**Re: State Significant Development (SSD 6766) - SIMTA Intermodal Stage 1 at Moorebank**

I refer to your request to review the documentation in relation to the above and its potential impacts on your property, Glenfield Farm, an item of State and Local Heritage significance. We have undertaken a review and the main areas of concern are:

Figure 2 : Noise catchment areas and noise monitoring locations

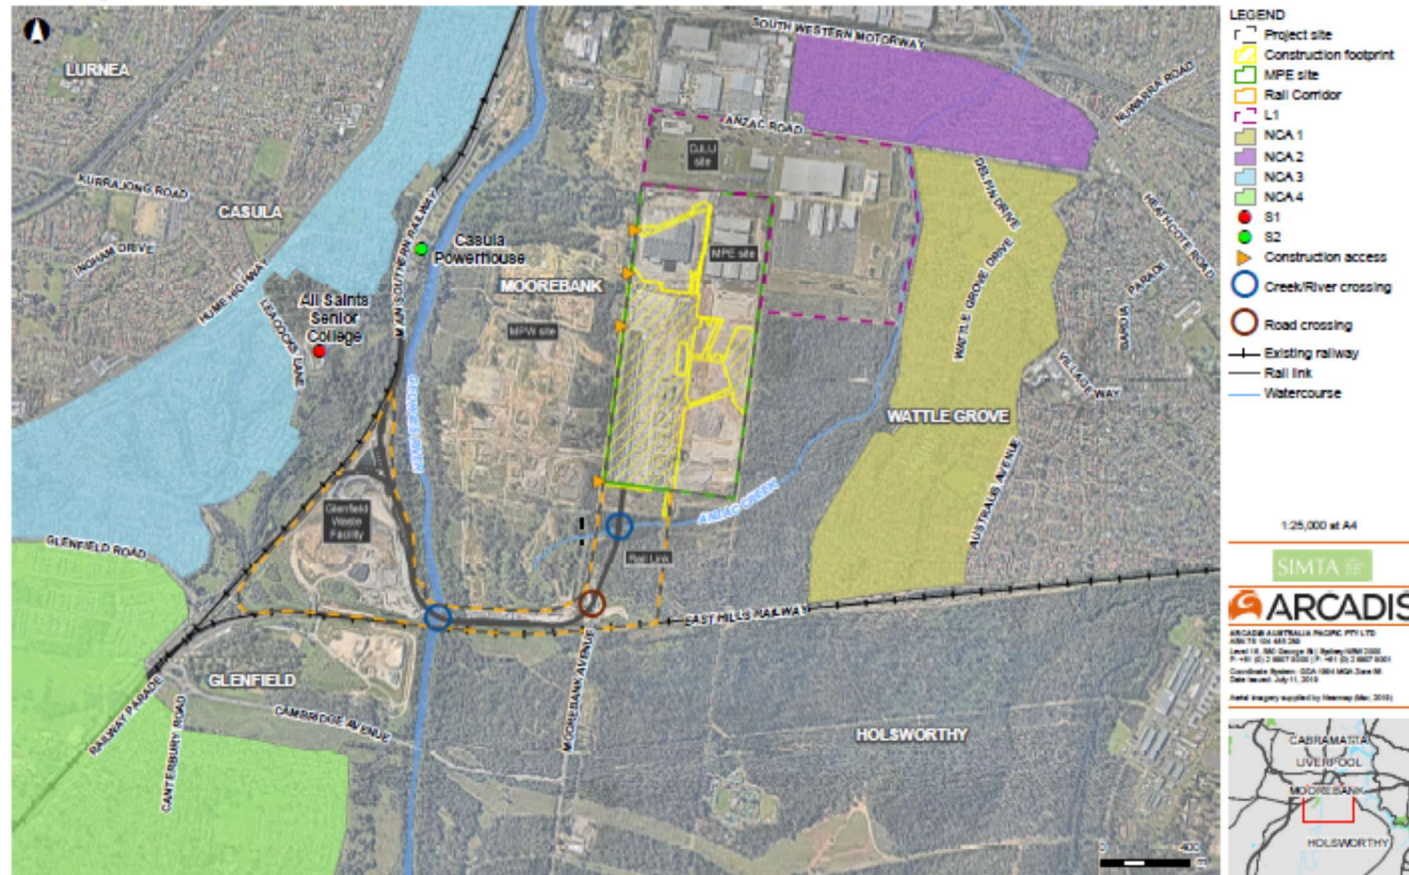
Table 3-3 relates to intrusive noise from the intermodal site and indicates a predicted noise level of 38dBA in NCA3 in adverse weather conditions. This is only 1 dBA less than the stated criteria of 39. Given that the subject site is the closest receiver within NCA3, it is likely that the relevant criteria will be exceeded. This is not an acceptable outcome.

Table 3-4 relates to sleep disturbance from the intermodal site and indicates a predicted noise level of 48dBA in NCA3. Again this is only 1 dBA less than the stated criteria of 49. Given that the subject site is the closest receiver within NCA3, it is likely that the relevant criteria will be exceeded. Further it is not clear whether this assessment allows for adverse weather conditions. This is not an acceptable outcome.

Part 3.5 deals with the impacts from the rail interchange. Table 3-7 relates to the northern connection and indicates that the noise levels for NCA3 will exceed the relevant criteria both where rail curve 'squeal' has been factored in and also where it has not. In the worse case the breach is significant – 11dBA. This is likely to be even higher on the subject site. It is noted that noise levels in 3 of the 4 residential areas monitored will exceed the recommended criteria. The only justification for the proposal offered is that the noise levels are already significant and therefore the increase will not be noticeable. However no evidence is provided to compare the existing and proposed scenarios and the criteria set for each location is reflective of the existing noise environment and so this is already factored into the assessment. The exceedances are hugely significant and will result in a very poor quality of life for the affected residents, particular my clients who reside closest to the rail interchange.
